## Application for a Non-Material Amendment Following a Grant of Planning Permission

Demolition of existing outbuildings; erection of new outbuilding for ancillary domestic use, with associated works.

23/00022/HOUSE

Amendment to the design and size of proposed external doors in Garden Room (south-east elevation).

PROPOSED SOUTH EAST ELEVATION

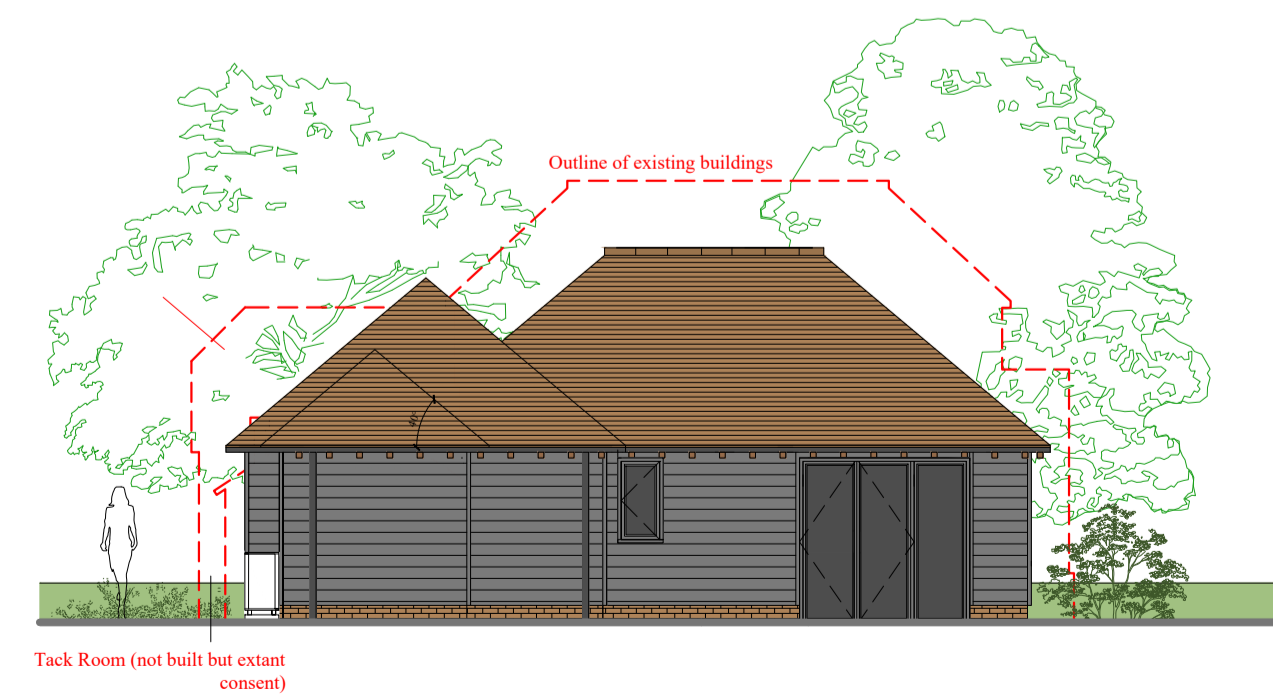
To provide natural daylight into this space.
